SUBJECT: **BRES2212-0037**
BUILDING RESIDENTIAL

Here are the results of all Inspections located at **198 FLETCHER TUTOR RD:**

Inspection Type: ROUGH IN
Scheduled Date/Time: 6/7/2023
Completed Date/Time: 6/7/2023
Inspector: Justin Ryan McLeod
Result: DISAPPROVED
Remarks: eTRAKiT Inspection Request
Notes: 6/5/2023 1:00 PM Nathan Benson
MECHANICAL
Contact Name: Nathan Benson
Site Address: 198 FLETCHER TUTOR RD
Phone: 9196248943
e-Mail: nate.benson123@gmail.com

SHEET NAME: <b>LOFTED BARN</b>	SCALE: <b>5/8" = 1'-0"</b>
SHEET SIZE: <b>SEE PLAN</b>	DRAWN BY: <b>DOUG GAITHER</b>
DATE: <b>07.08.19</b>	
SHEET NAME: <b>TYPICAL WALL SECTION</b>

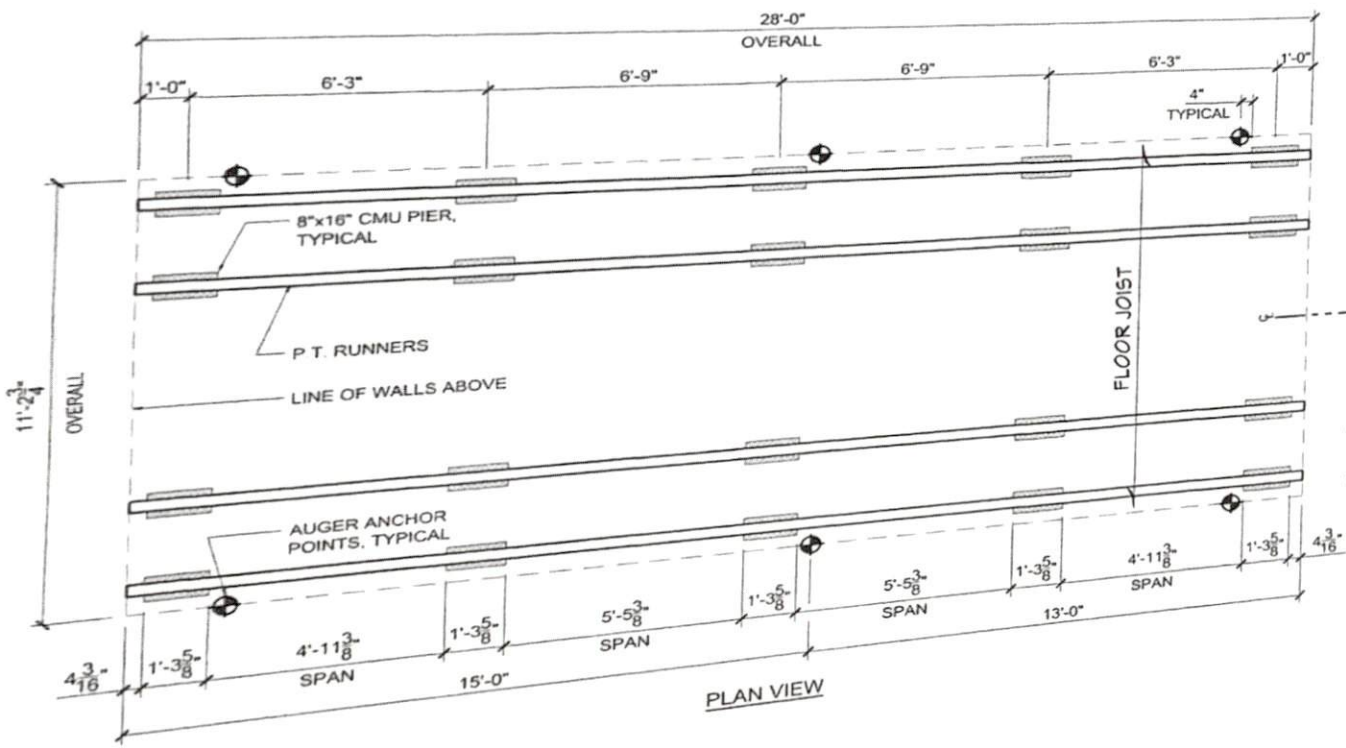
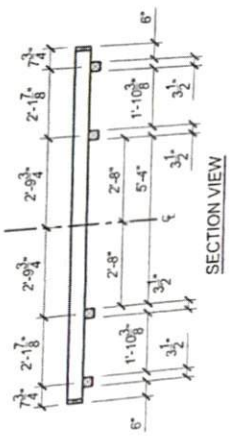
1. Fur down rafters or add ceiling joists for r38 insulation.
2. Studs over bored on exterior wall for plumbing by sink.
